**RESPONSE TO
ENVIRONMENTAL IMPACT STATEMENT

NORTHCONNEX M1-M2 TUNNEL**

**Director – Infrastructure Projects
Department of Planning and Environment
Application Number – SSI 13_6136
Major Projects Assessment
GPO Box 39 SYDNEY NSW 2001**

12 September 2014

Current Transurban Proposal: LONGITUDINAL SECTION - NORTHCONNEX M1-M2 TUNNEL

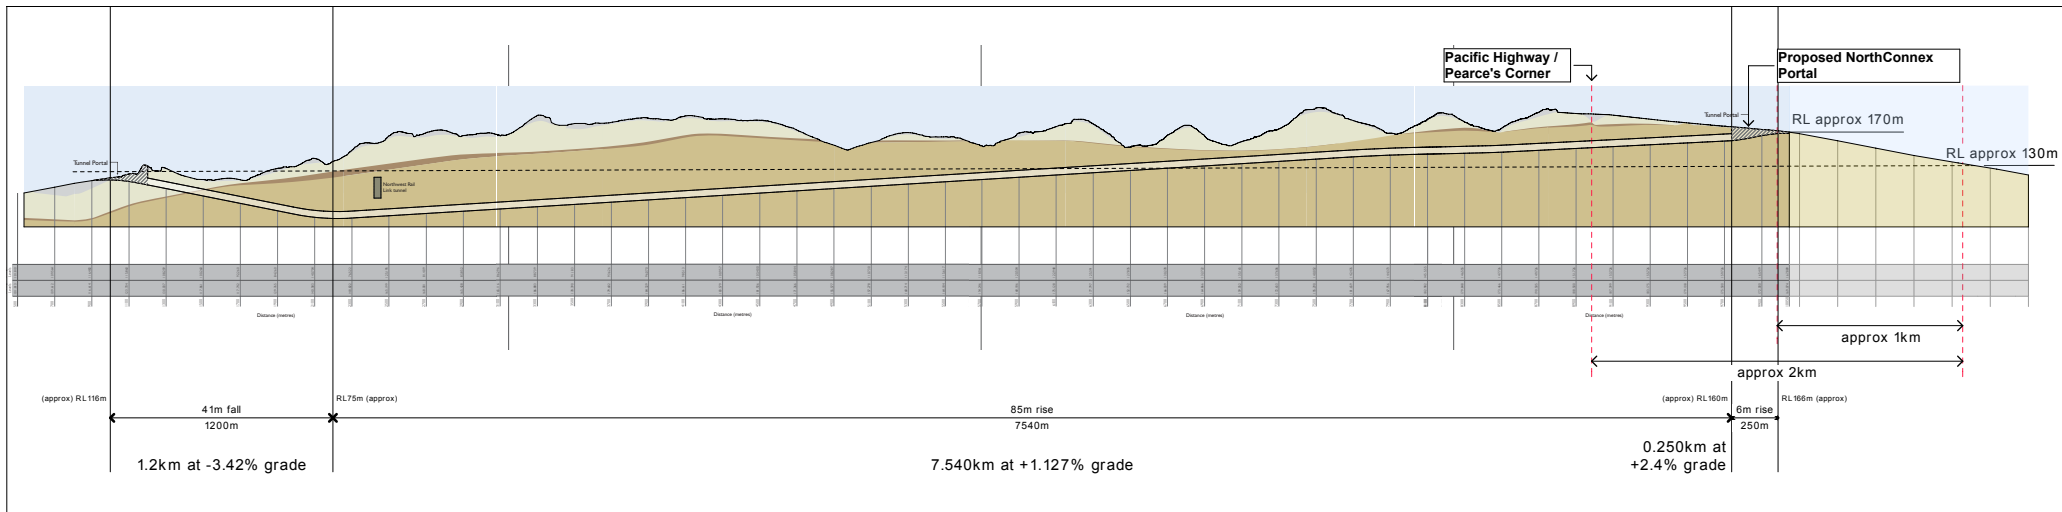
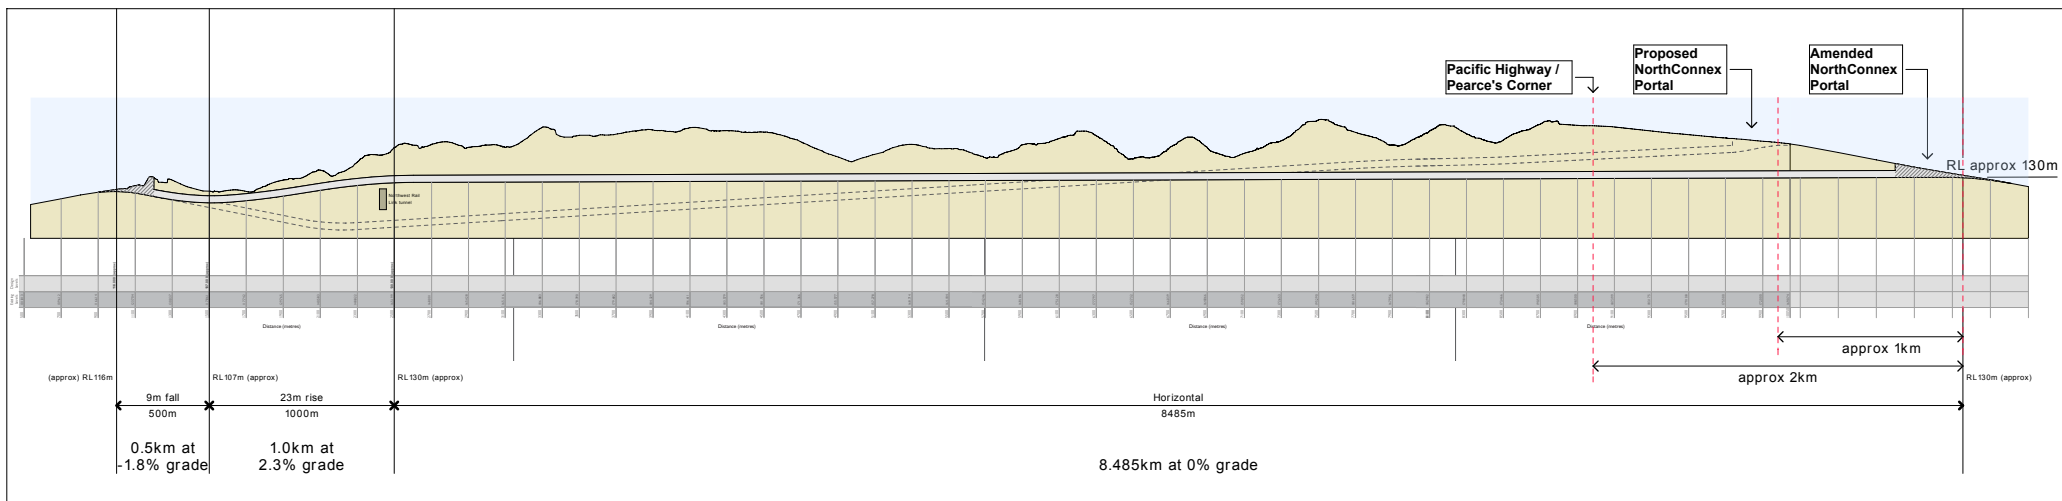
The proposed northern portal does not take advantage of the existing topography. The design forces all vehicles to go up hill in the tunnel, only to exit and immediately go back down the hill along the M1. Forcing all vehicles to do this is a waste of energy, directly resulting from the poor design of the tunnel.

The proposed tunnel has a gradient over its entire length. Tunnels with gradients have higher emissions than tunnels that are built horizontal¹.

The proposed tunnel gradient will cause impaired air quality in the northbound tunnel and outside the tunnel adjacent to the stack.

There is a total omission of site contour analysis across the entire route of the tunnel. This is most pertinent at the northern interchange as the M1 motorway falls down hill north of Pacific Highway. Approximately 2km north of Pacific Highway, the reduced level is 130m which is approximately same level as the M2 at Beecroft (see long section drawing above).

The Equilibria Proposal would enhance the NorthConnex M1-M2 Tunnel by extending the tunnel by approximately 1km. As the M1 falls down hill north of Pacific Highway, a horizontal tunnel can join the M1 on grade, with minimum vehicle emissions. The smoke stack would be close to the Hornsby industrial area, not immediate to the residential area in Wahroonga.
